## DECISION DELEGATED TO HEAD OF PLANNING

**Application No:** H14-0508-26      **Applicant:** Mr J Fleming

**Proposal:** Proposed two storey rear & side extension & render of existing house including alterations - approved under H14-0321-26. Amendments to include additional window to rear bedroom and addition of stone cills to bottom of all windows to front elevation

**Location:** 3 Penway Drive Pinchbeck Spalding

Elevation 03 -Rear

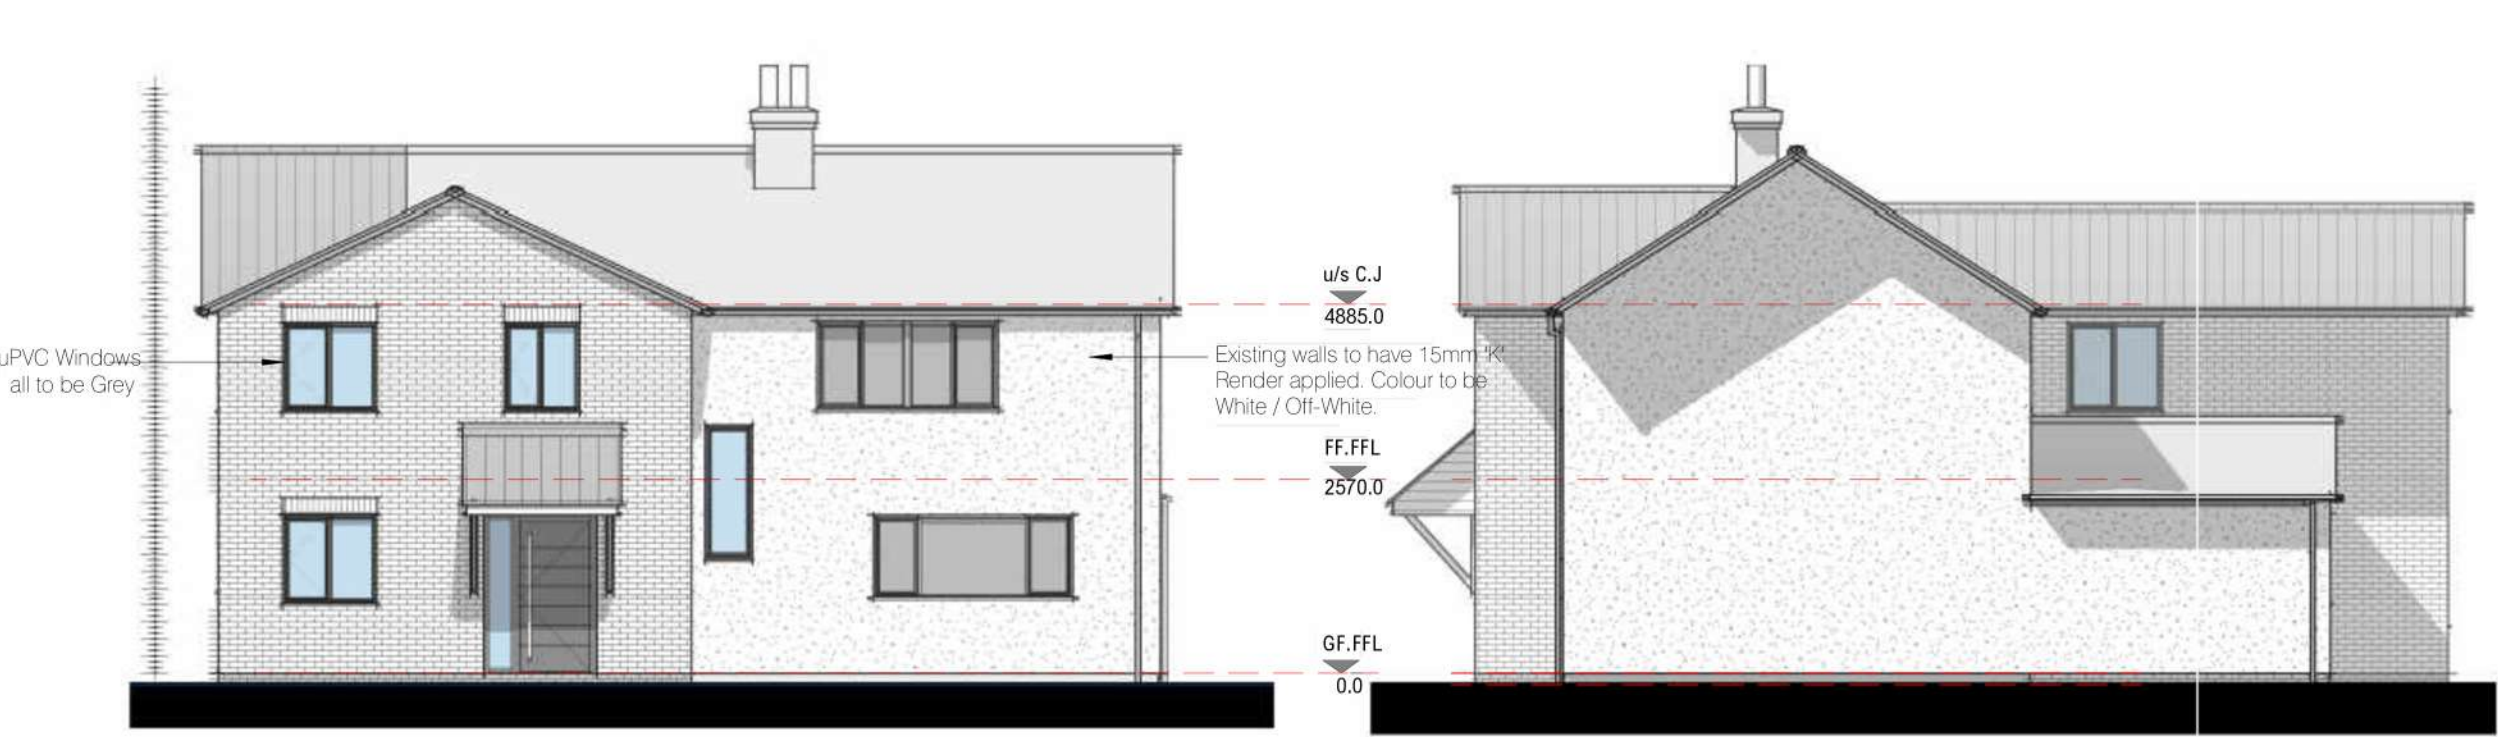
This is an application made under S96A of the Town & Country Planning Act 1990 (as amended), seeking to amend planning approval H14-0508-26. The proposal seeks to change a large window on the rear elevation of the extension to two smaller windows, and the addition of stone cills to the bottom of all windows to front elevation.

8.The amendments would not result in a fundamental change in the design of the building or the wider site. The amendment to the rear elevation would be entirely hidden from the public realm, and in any event would have a minor effect on the appearance of this elevation. The addition of stone cills would not be a fundamental alteration to the building's appearance.

10. The additional window would replace an already approved window, reducing additional views. In any event, the window primarily offer views of the rear garden, and any views of obtained of the neighbouring property would be at an oblique angle.
